Your Ref: OWPC19540
Our Ref: LU/189/18/PDH 05-07-2018
Please ask for:
Zac Denton

Notification under extended development rights for new proposed single storey rear extension extending 5.96m from the original rear wall of the dwelling house, 3m high with an eaves height of 2.55m

48 Northway Road Littlehampton

48 NORTHWAY ROAD, LITTLEHAMPTON
Existing details 01

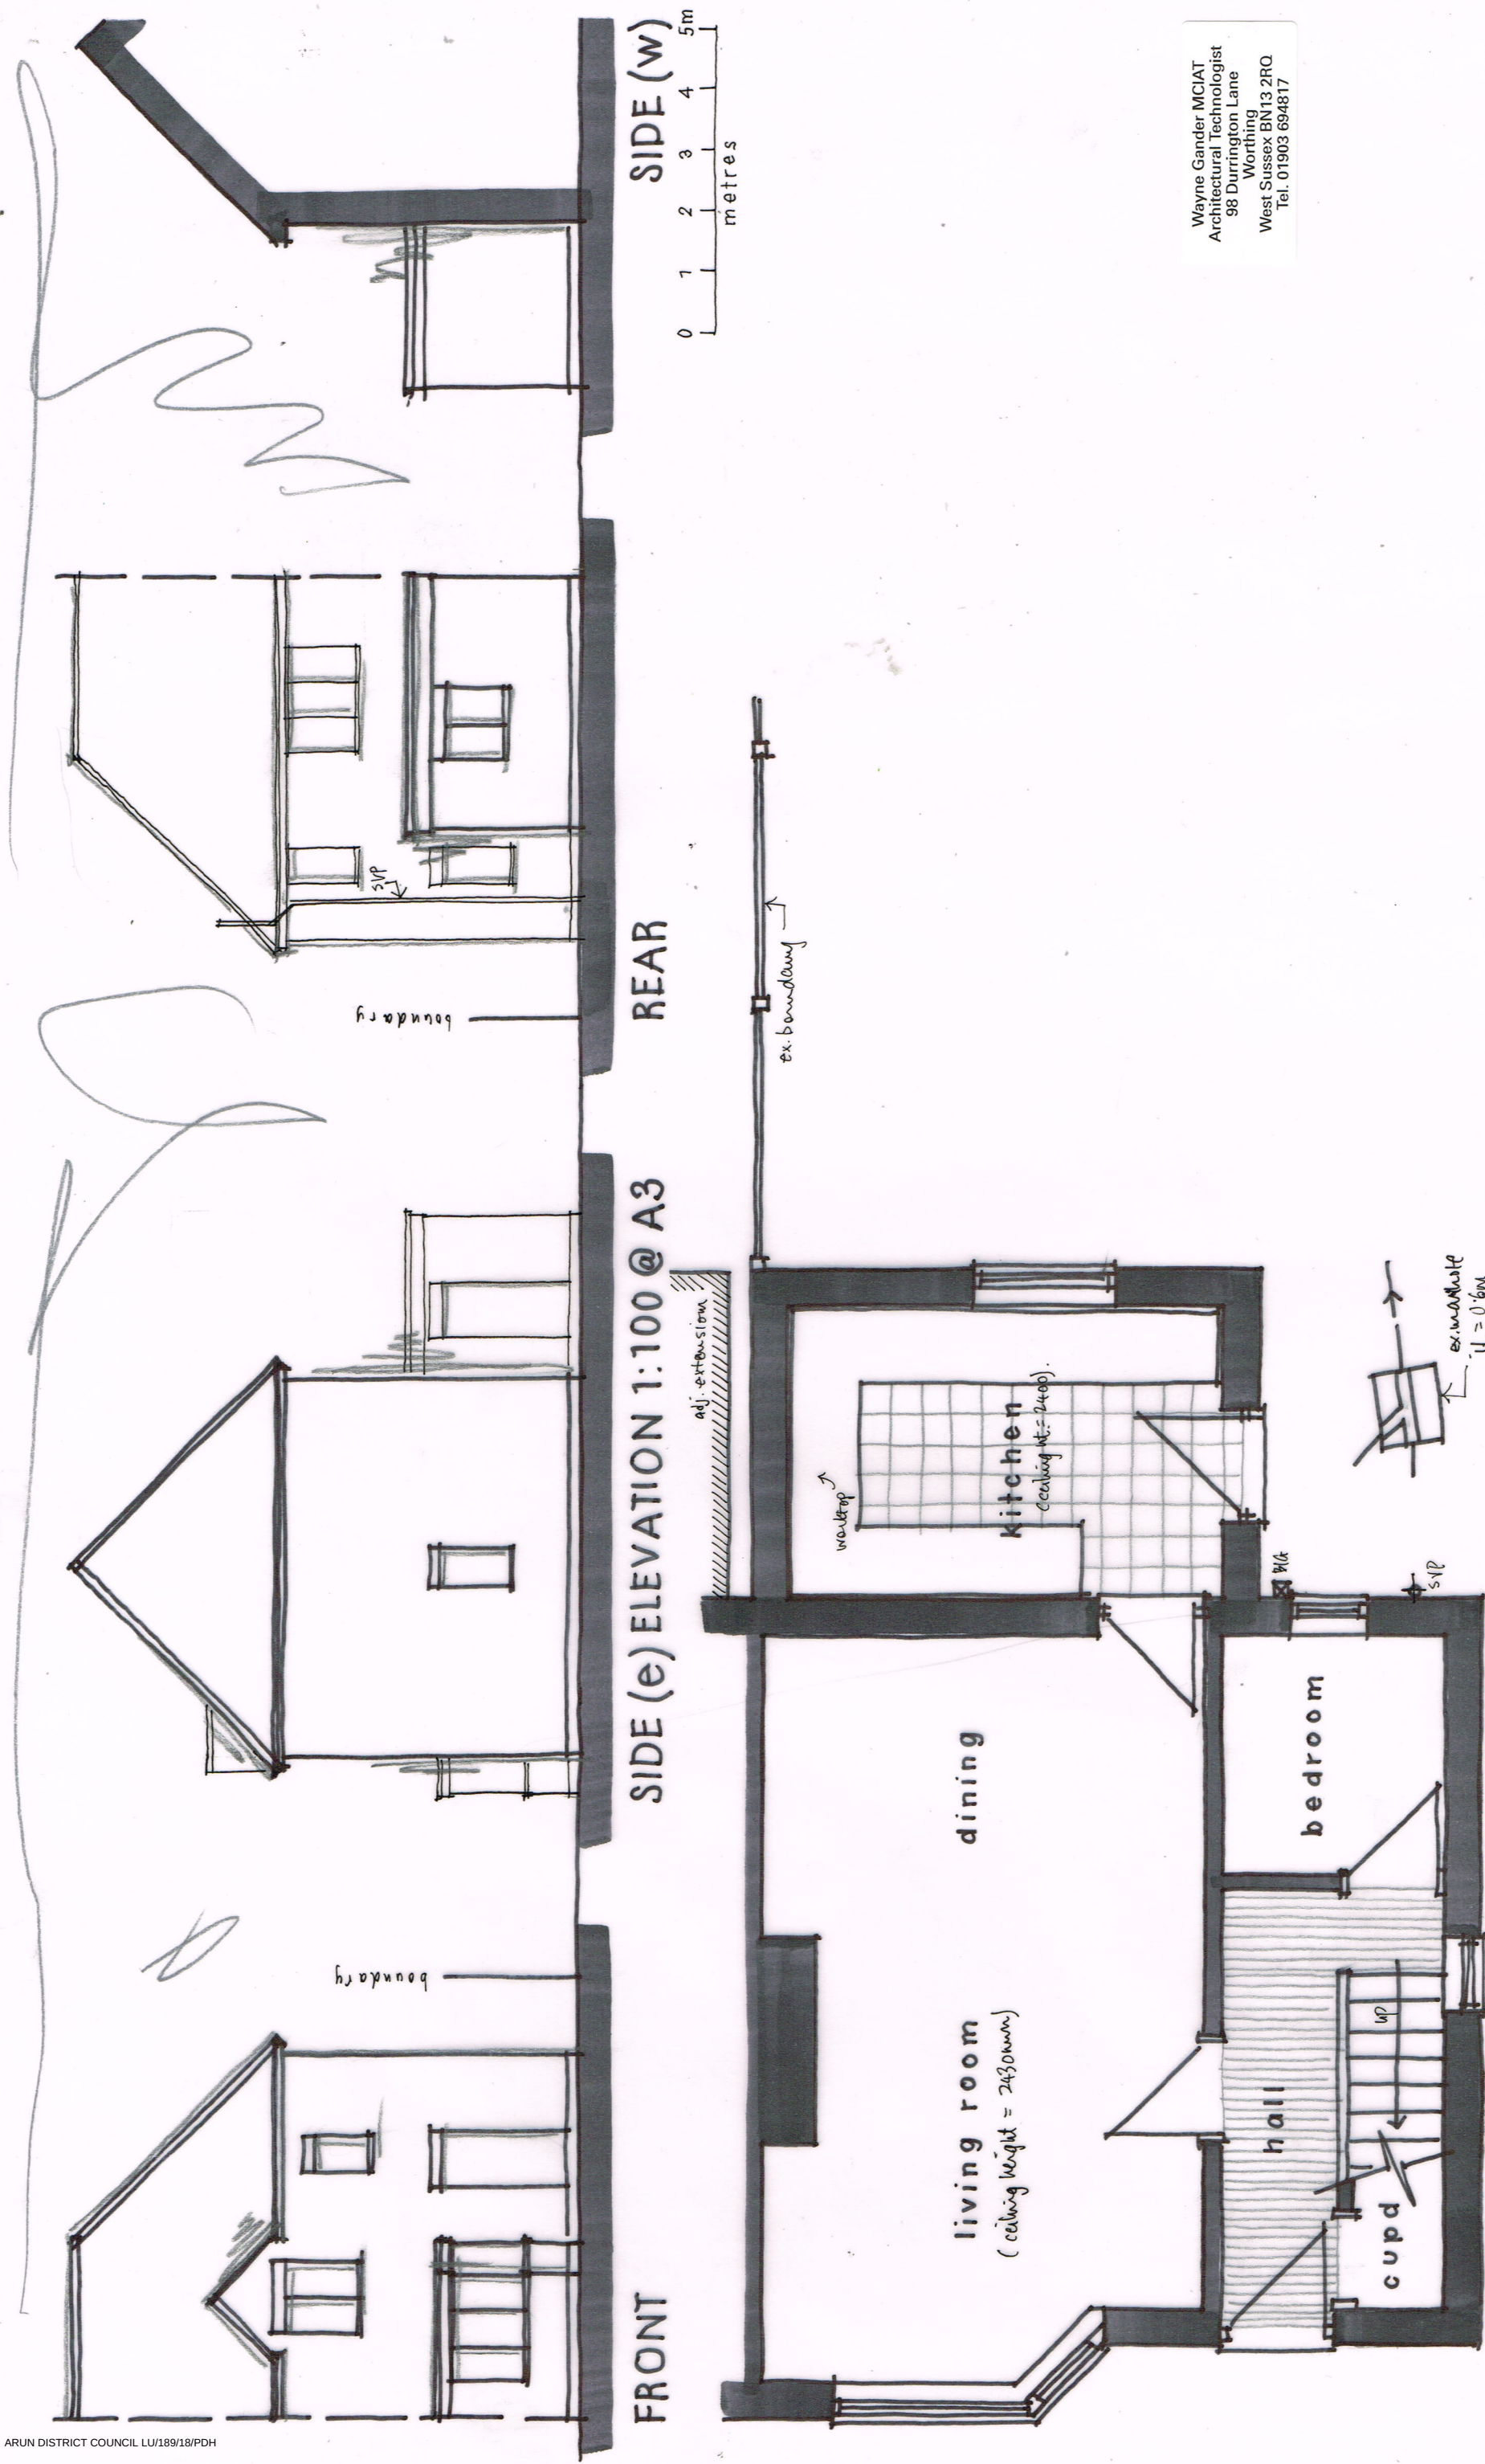
My concerns relate to Mr Jones existing extension and intentions to build directly onto their existing extension wall, currently overlapping into my garden. I have had extensive discussions with Land Registry who are unable to give exact boundary line; they said boundary's change over time. When I moved in 31 years ago, existing extensions and the fence line was as it currently is.

1. The plans submitted as part of the application, do not make specific reference to the correct and defined boundary that exists between both properties. I am of the opinion that this has been done to intentionally miss-lead. If the boundary as shown is correct, then the proposed extension can only be constructed by way of entering my property (e.g. concrete foundation bearing, scaffolding, guttering, roofing etc.). Even if the correct line of the boundary is such that it runs midway between the properties, there is still insufficient distance to allow construction without the need to enter my property. This would be the subject of a Party Wall agreement for which the Applicant has dismissed to provide and/or enter into. Further, if the brickwork, which is shown on the boundary line ever, required maintenance, this too could only be accessed by way of entering on my property. For the avoidance of doubt, I consider any such entrance to my property as Trespass, and will contact the relevant authorities should the need arise. Therefore, if the Application was to be passed (which it should not as currently proposed), it should only be done so with the strict condition that the external walls are constructed at least 1 metre away from the

boundary line between both properties.
